From: [Mau, Russell E \(DOH\)](#)
To: [Jeremiah Cromie](#)
Cc: [Holly Erdman](#); [Smits, Brenda M \(DOH\)](#)
Subject: RE: SP-22-00005 Johnson-Duvall Notice of Application
Date: Tuesday, January 10, 2023 10:06:44 AM

Subject: SP-22-00005 Johnson-Duvall Notice of Application

CDS is requesting comments on the following short plat application: SP-22-00005 Johnson-Duvall. Links to the file materials can be found below. The comment period will end Friday, January 27, 2023 at 5pm. **CDS will assume your agency does not wish to provide comment if not received by this date.** Please let me know if you have any issues accessing the materials or any other questions.

JOHNSON-DUVALL SHORT PLAT
 PART OF SECTION 25, T. 18 N., R. 18 E., W.M.
 KITTITAS COUNTY, WASHINGTON

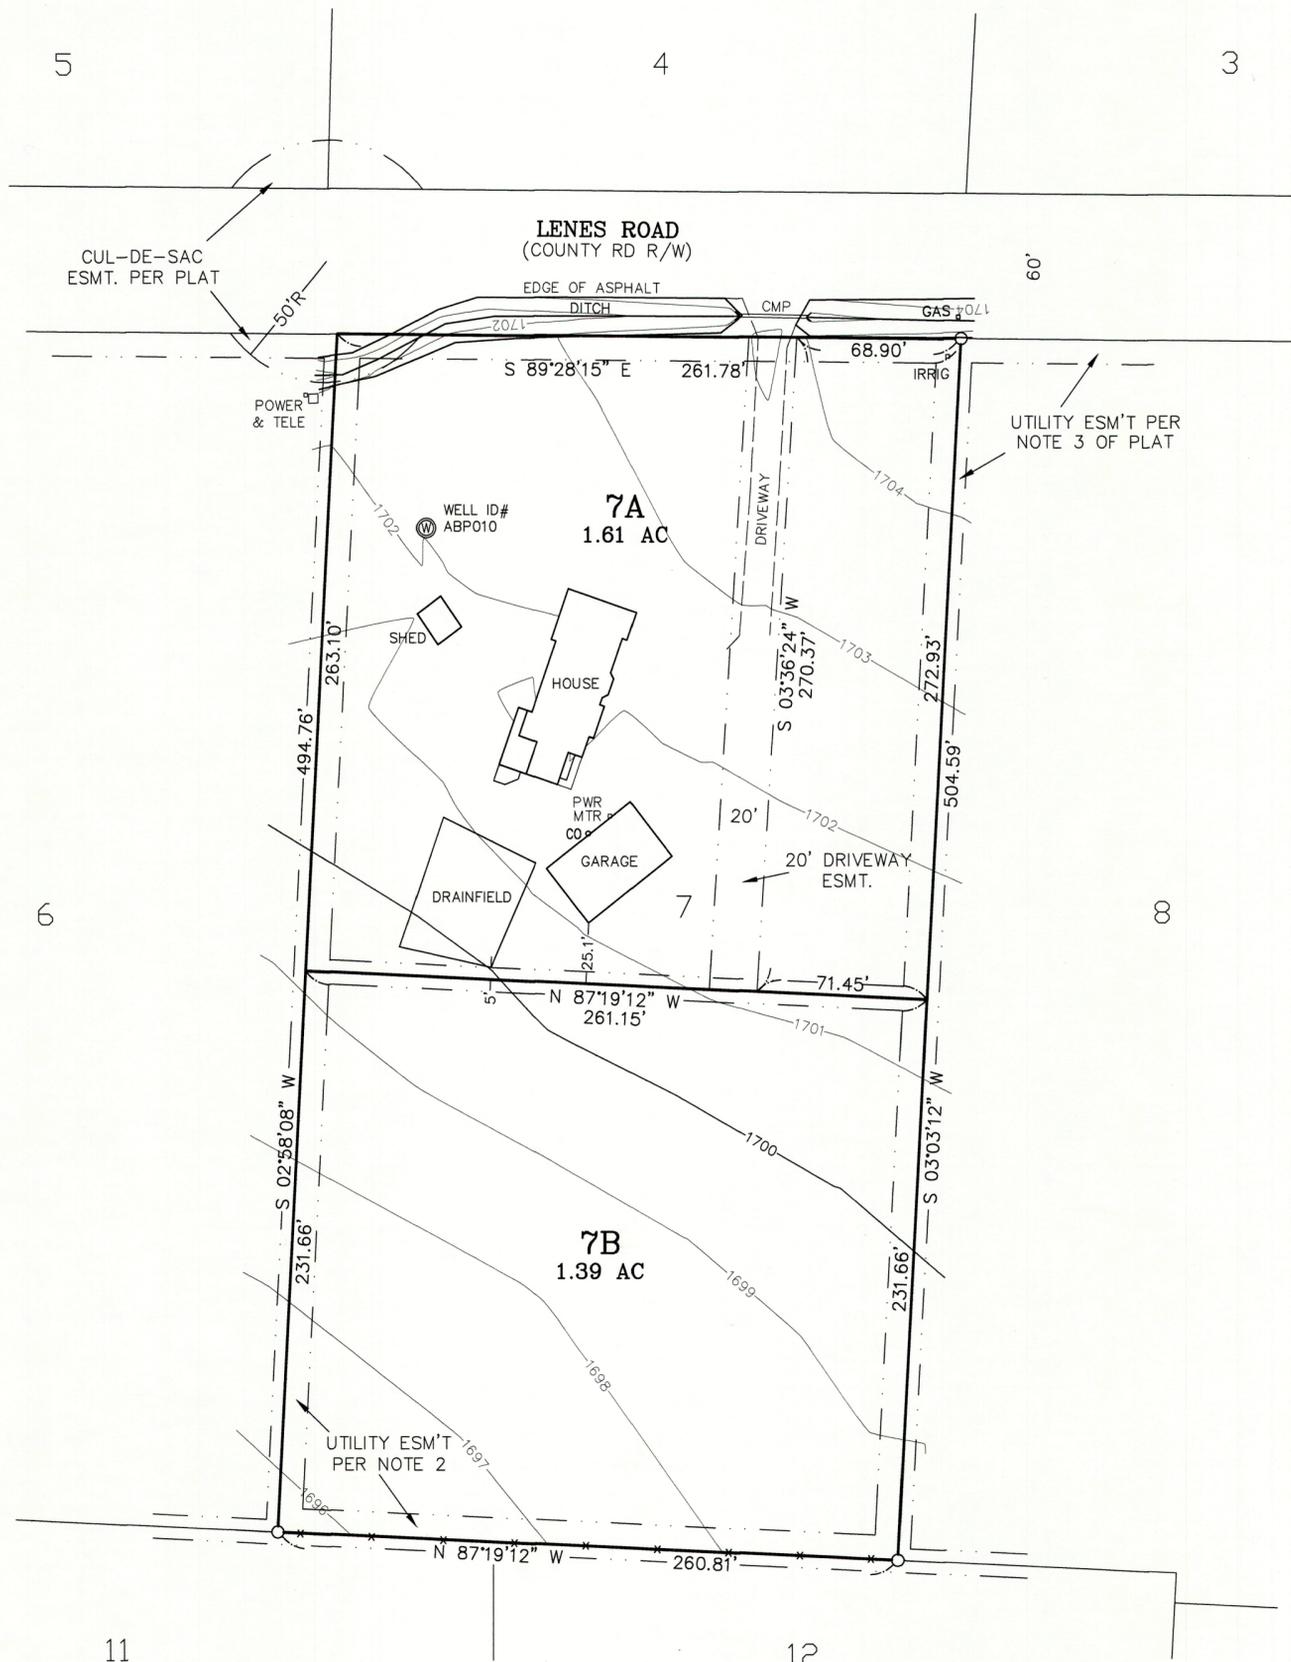
- For groundwater for drinking water, the subdividing of this property is considered a “project” and all groundwater extraction needs to be evaluated as a total. In other words, the project narrative states that the two properties will use a shared well – the total extraction through this shared well is held to a single exempt well quantity. The property owner should consult with the State of Washington Department of Ecology to confirm.
- The applicant should also consult with Kittitas County regarding any possible groundwater withdrawal mitigation.
